Re: C & D Land Corp
423 Wyoming Blvd. SE
30-Day Temporary Certificate of Occupancy
Transportation Development Final Inspection
Engineer's Stamp dated 11-12-20 (L19-D023)
Certification dated 03-28-23

Based upon the information provided in your submittal received 03-29-23, Transportation Development has no objection to a 30-day Temporary Certificate of Occupancy based. This letter serves as a "green tag" from Transportation Development for a 30-day Temporary Certificate of Occupancy to be issued by the Building and Safety Division.

**RE: APPROVED TRAFFIC CIRCULATION PLAN FOR BUILDING
PERMIT CERTIFICATION
REQUEST FOR PERMANENT CERTIFICATE OF OCCUPANCY
411 WYOMING BLVD SE ALBUQUERQUE NM 87123**

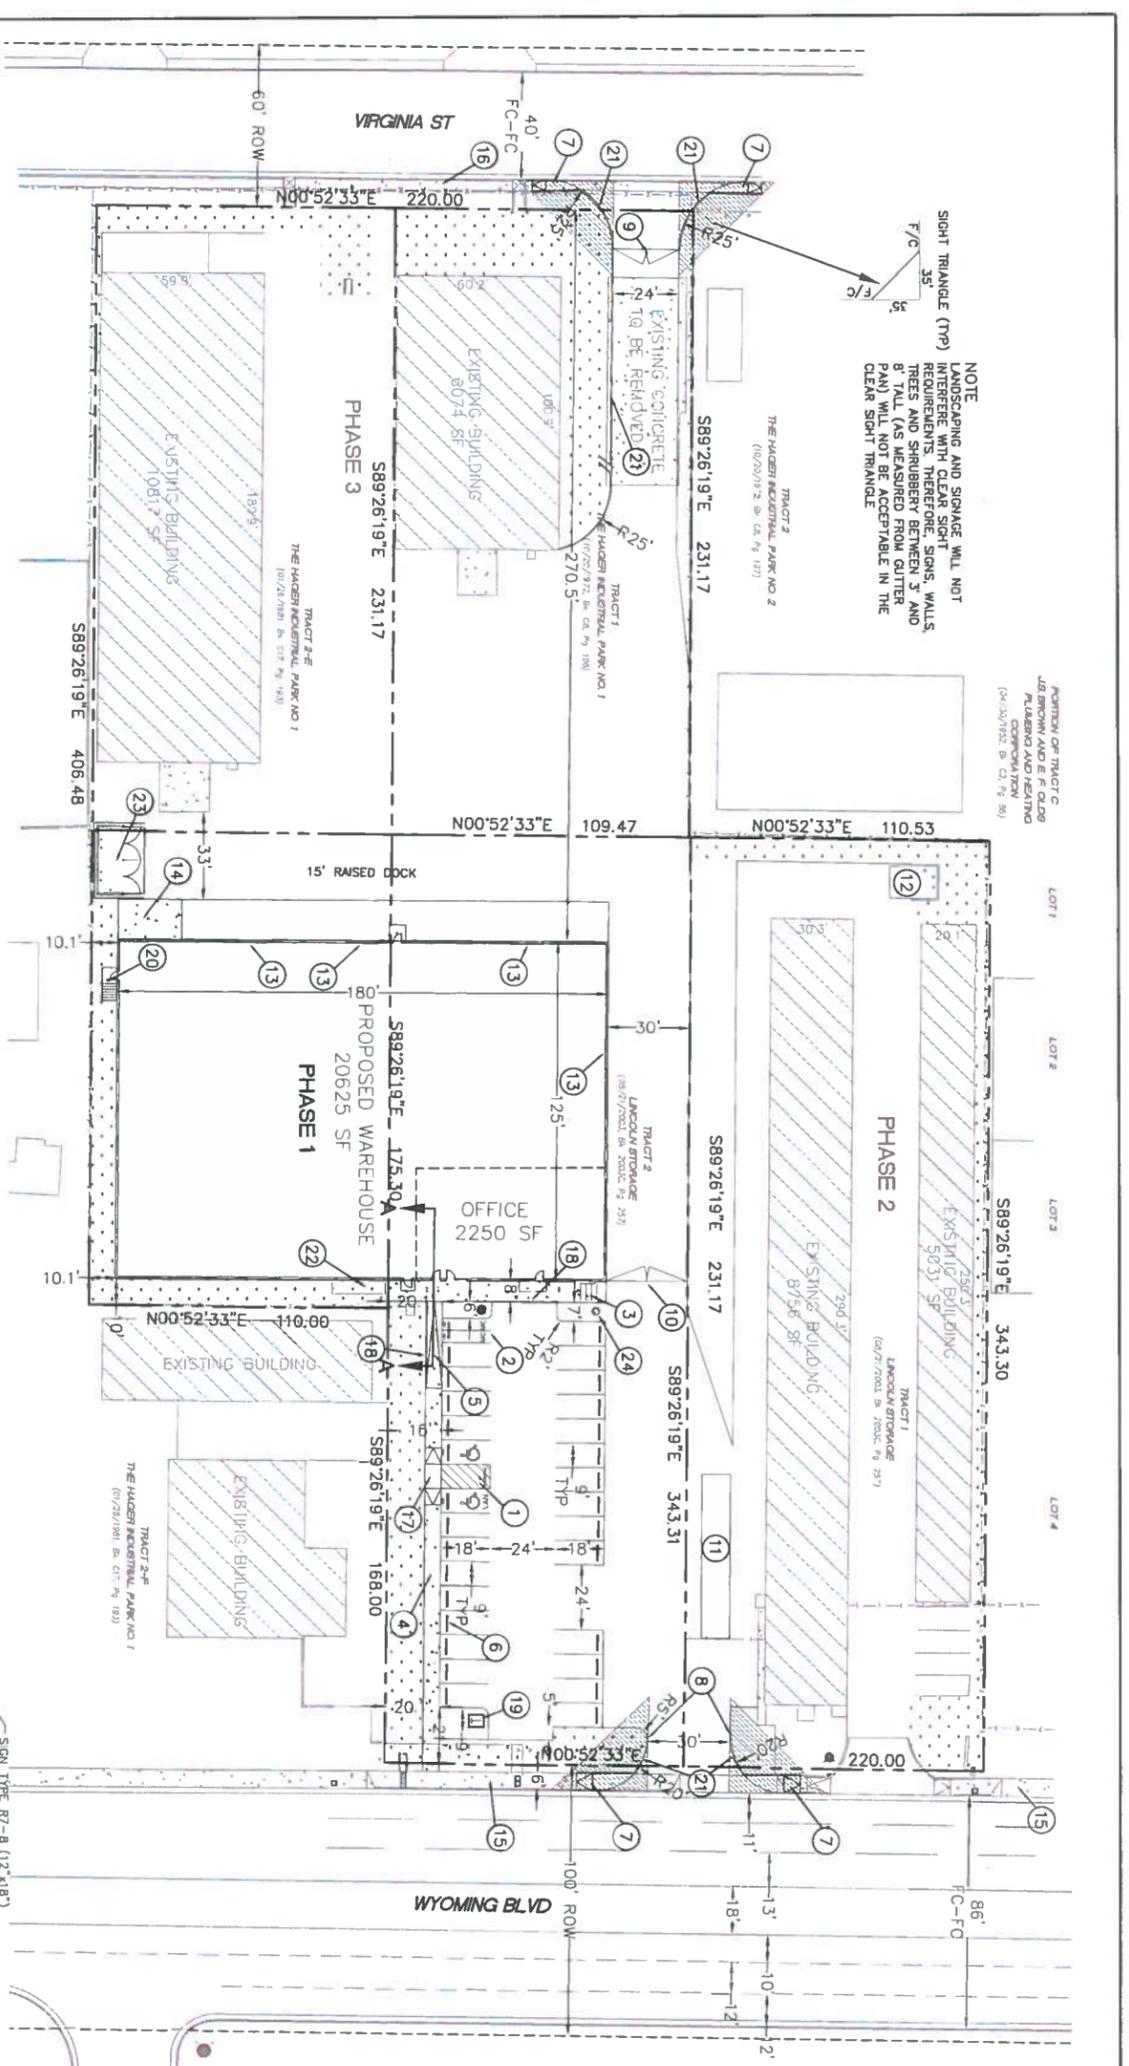
- Please install Truncated Domes on all wheelchair ramps located within the public right of way.
- Per site visit the cross slope for the south leg of the site access off Virginia St. is 3.4%. Per city requirement, the maximum cross slope is 2%. Please fix this issue.
- Per approved site plan please provide 6' wide ADA pathway from the public sidewalk to the building entrance.
- Ribbon Bike Rack is no more permitted. Please provide Bike Rack per the new requirement.
